**APPLICATION FOR A DEVELOPMENT CONSENT ORDER (“DCO”)  
BY WREXHAM POWER LIMITED TO AUTHORISE THE  
CONSTRUCTION, OPERATION AND MAINTENANCE OF 4 NEW  
COMBINED CYCLE GAS TURBINE ELECTRICITY GENERATING STATION WITH  
A RATED ELECTRICAL OUTPUT OF UP TO 299 MWe  
 (“PROPOSED DEVELOPMENT”)**

**LOCATION – KINGMOOR PARK SOUTH, TO THE EAST OF BRYN LANE ON  
THE WREXHAM INDUSTRIAL ESTATE, WREXHAM**

**LOCAL IMPACT REPORT AND COMMENTS BY WREXHAM COUNTY  
BOROUGH COUNCIL – ENVIRONMENT AND PLANNING  
(Council Reference P/2012/0837)**

Title
SPA Junction 1 - Abnormal Load

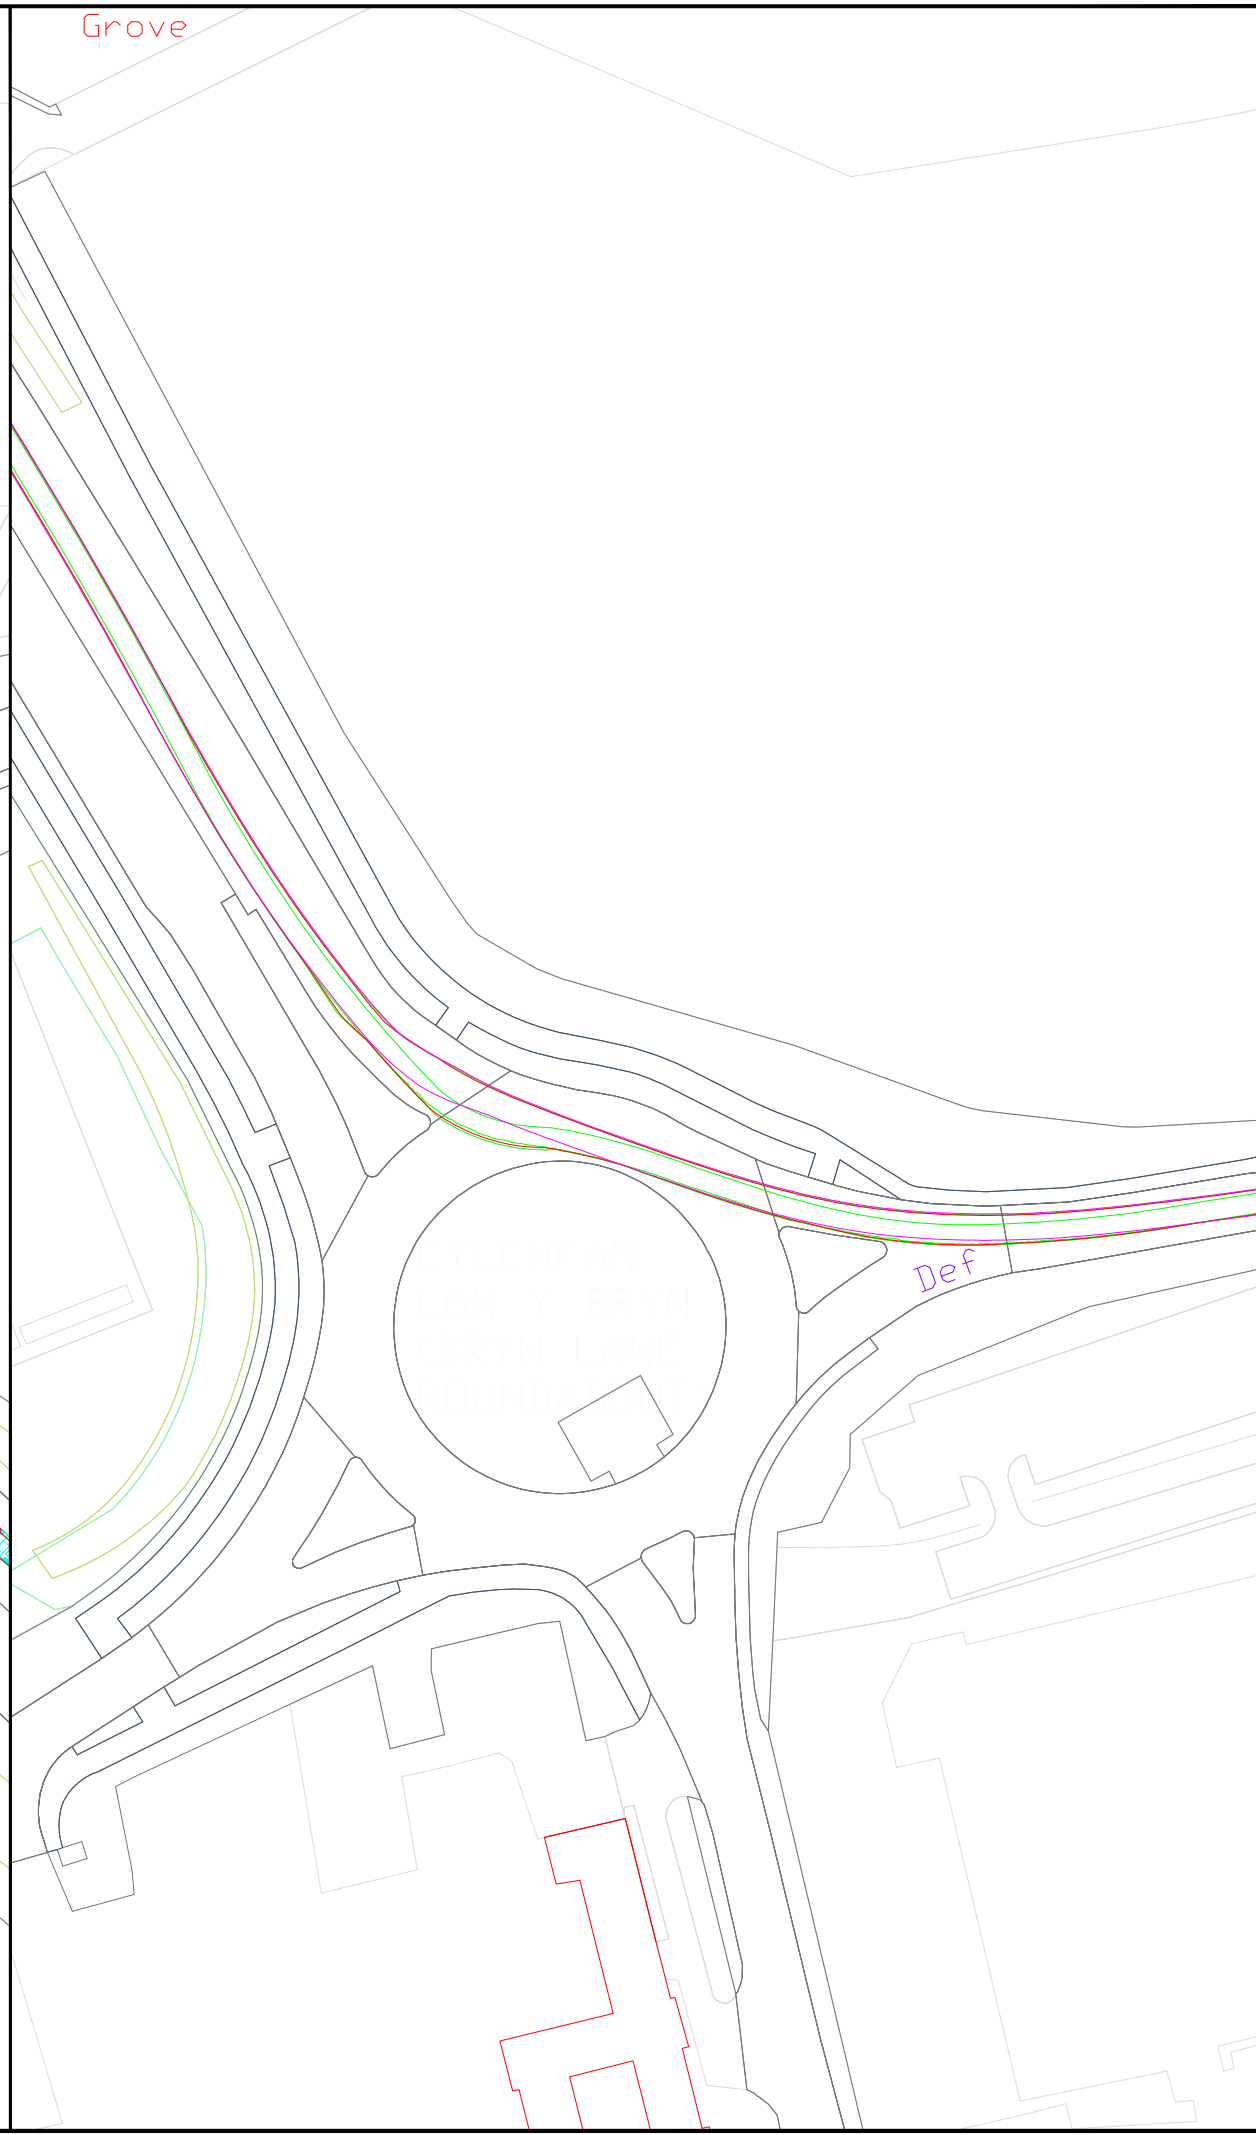
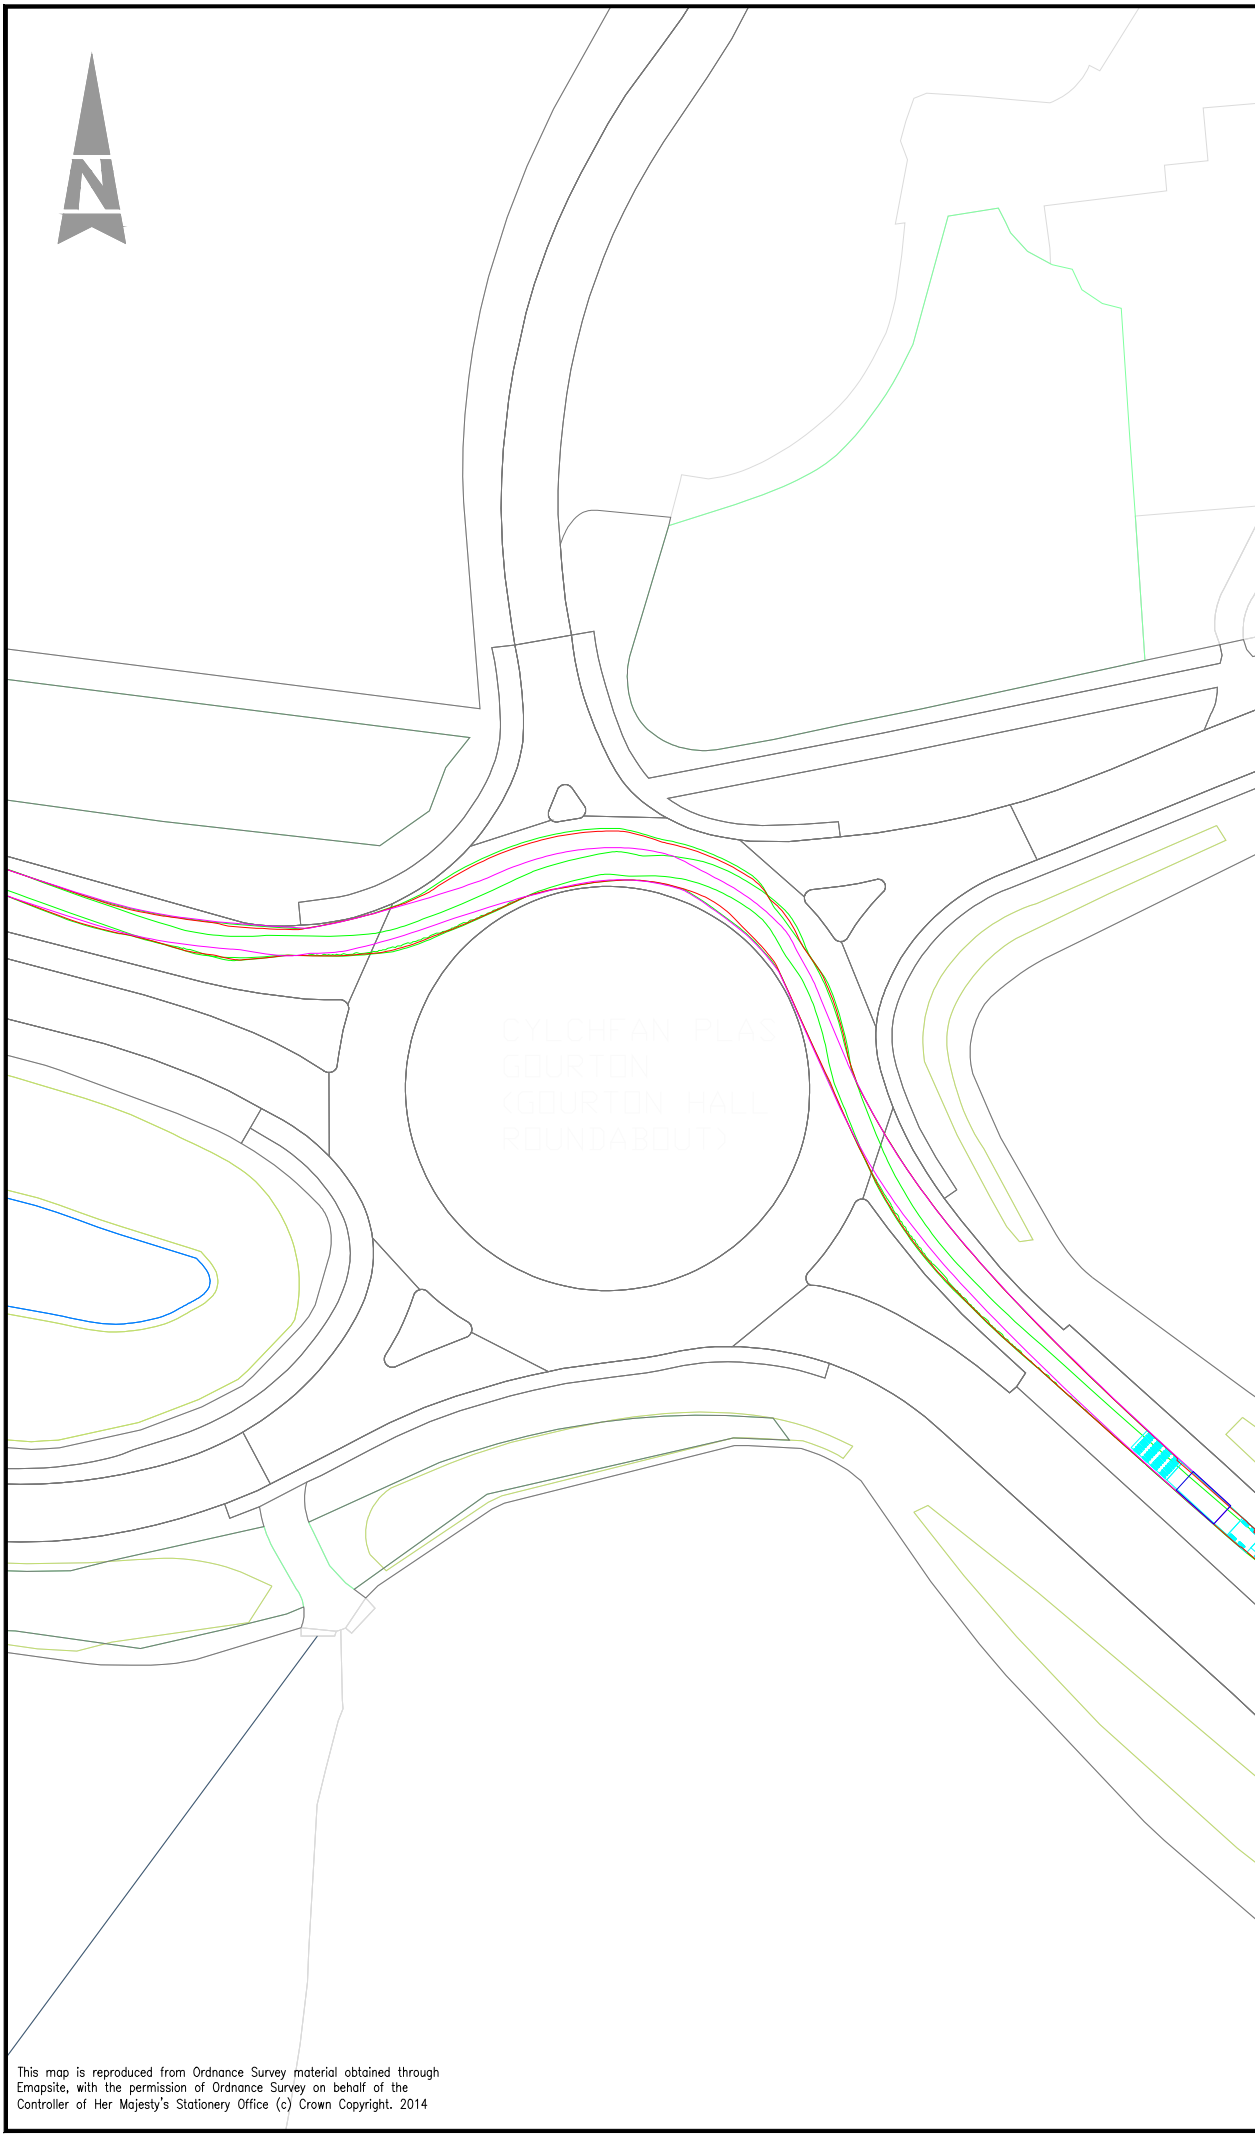
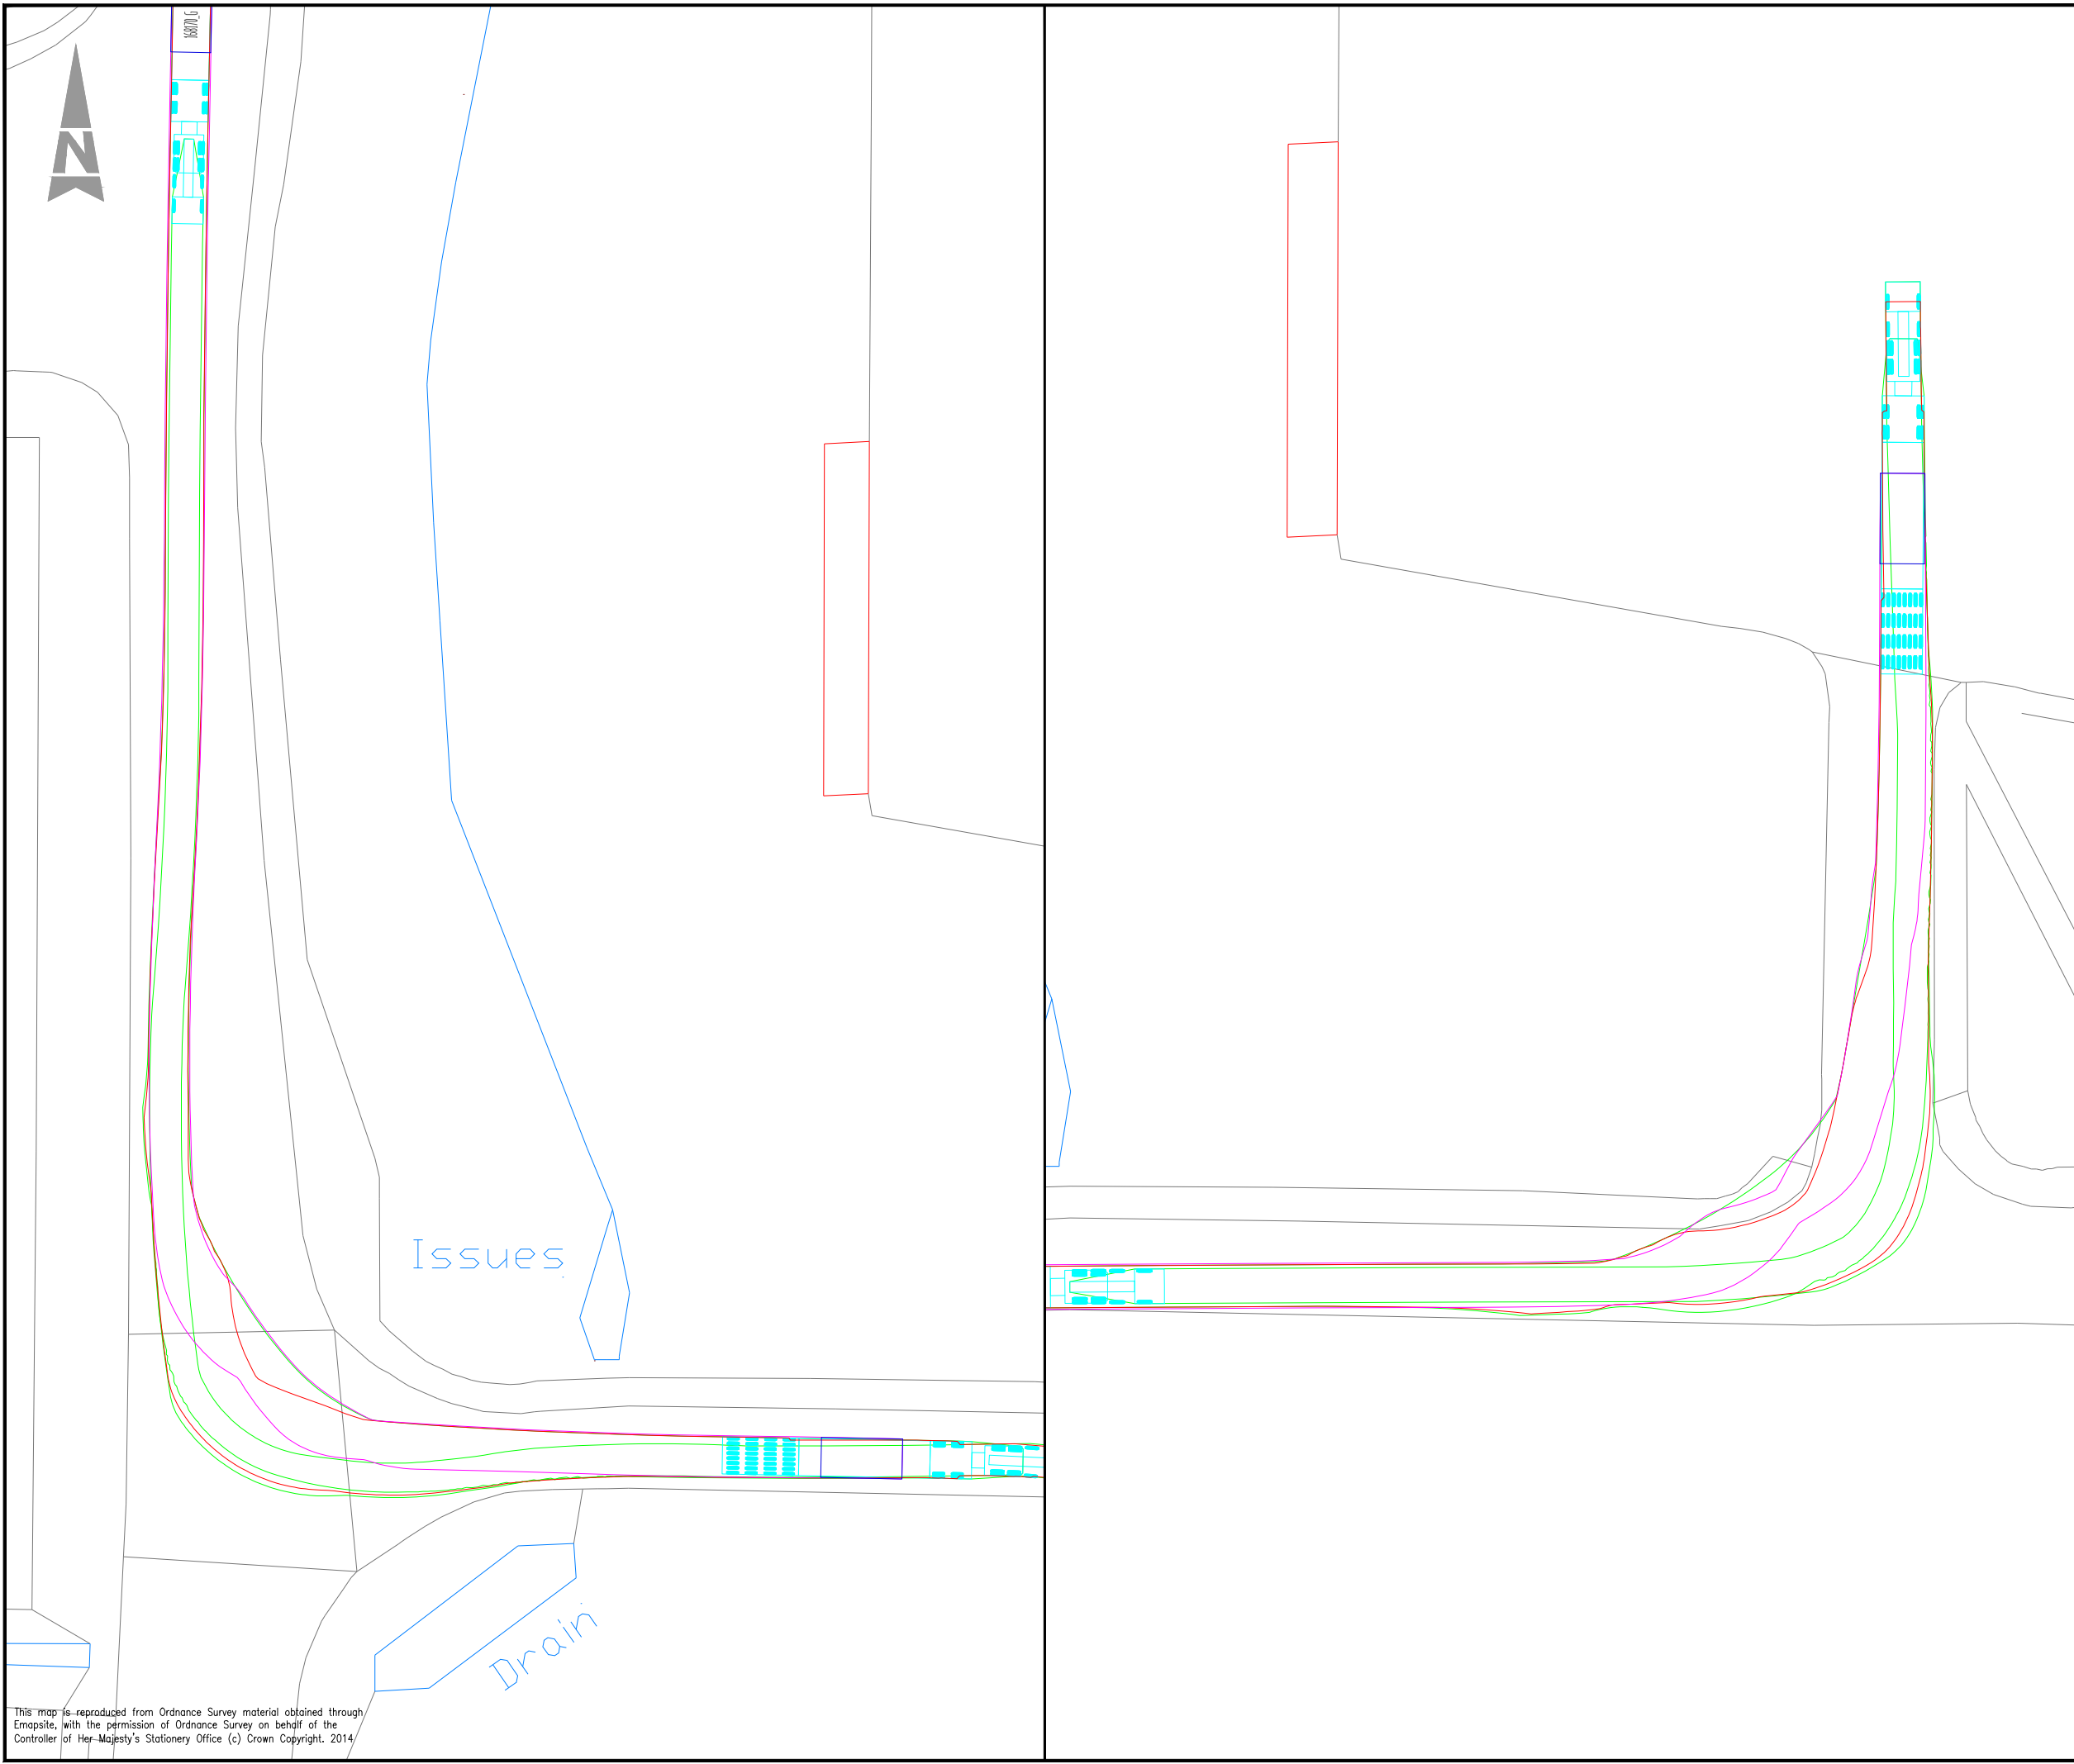
It is understood that a number of abnormal loads will be required to construct the proposed Energy Centre. Advance notification will be required to the Highway Authority to approve such movements.

Details of maximum size of HGVs likely to be visiting the site would need to be provided, including details of where vehicles will park / turn within the curtilage of the site during the construction period. Details should include swept path details of such vehicles (e.g. 16.5m long HGV) entering and existing the internal site access and turning within the curtilage of the site.
